Address: Fulstone 12-14 White Ley Bank Holmfirth HD9 7DL

Application number: 2025/90278	
What is the application for?:	Erection of stable block (within a Conservation Area)
Address of the site or building:	Westroyd Farm, Fulstone, White Ley Bank, New Mill, Holmfirth, HD9 7DL
Postcode:	HD9 7DL

Objection to Application 2025/90278

title General arrangement as proposed
number 24074D-02-P04
scale 1:100
size A2

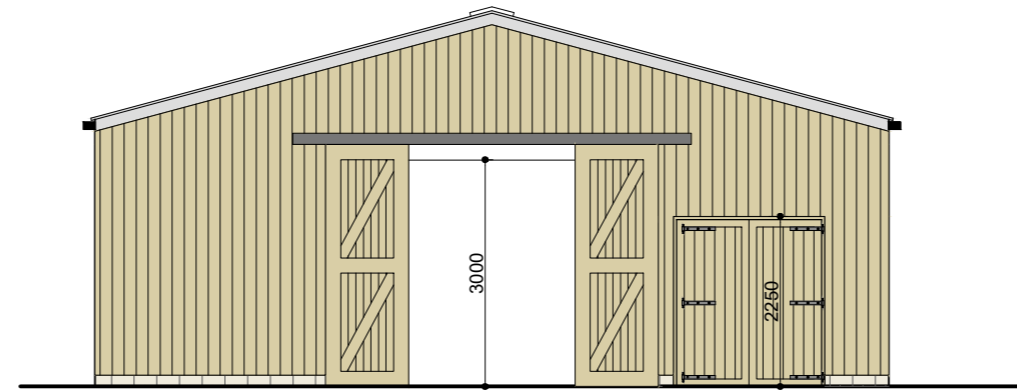
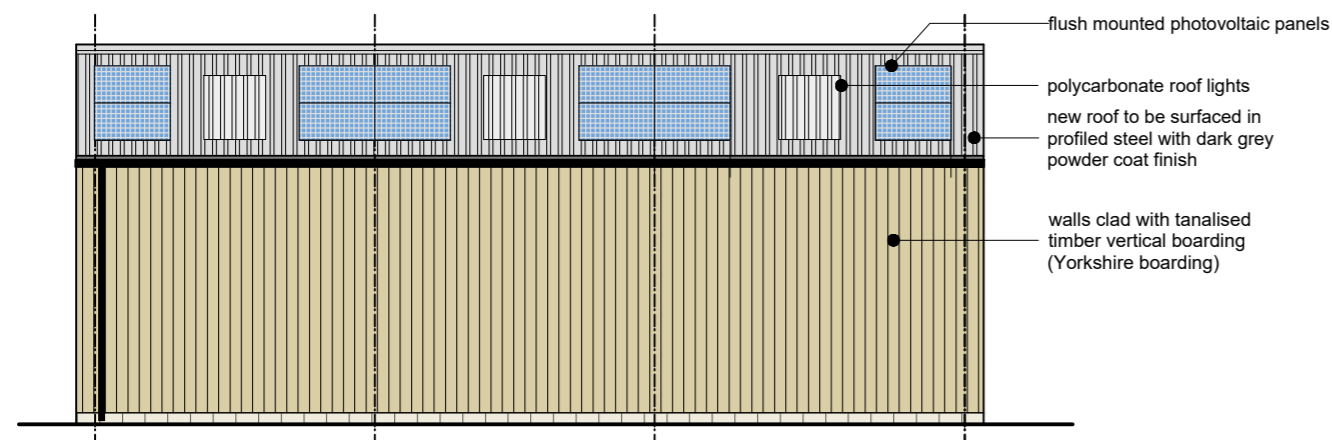
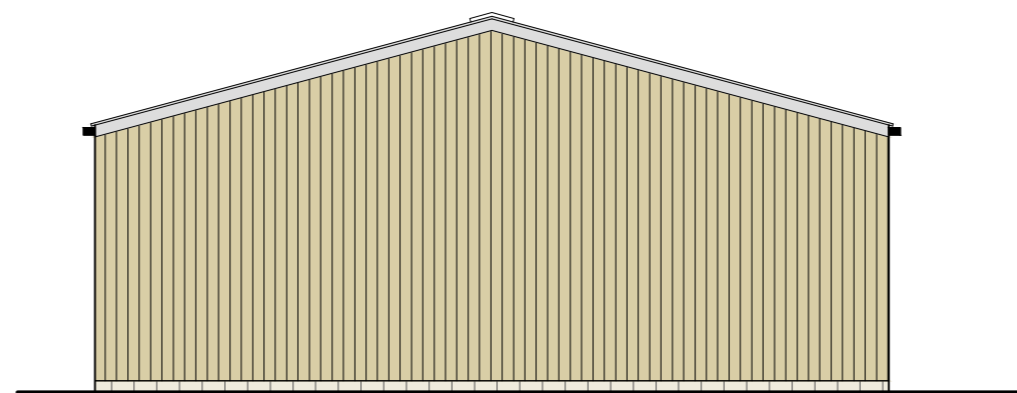
The proposed building is enormous, not looking like anything else in the area other than industrial units. It will totally block the views from the country lane of the surrounding countryside appreciated by many, not just residents of the hamlet. Because of recent remodelling of the land levels (by dumping) during the stripping out of the listed farmhouse adjacent, this exceptionally large and tall building will stand out sentinel over the vale of Fulstone and be visible for many miles in its incongruity. A similar stable and equine application (2022/62/90175/E) in Stocksmoor road was refused on grounds of "highway safety and efficiency" contrary to policy LP21 of KLP, though the visibility at this site was far better than at this current applications entrance on the bend of White ley bank.
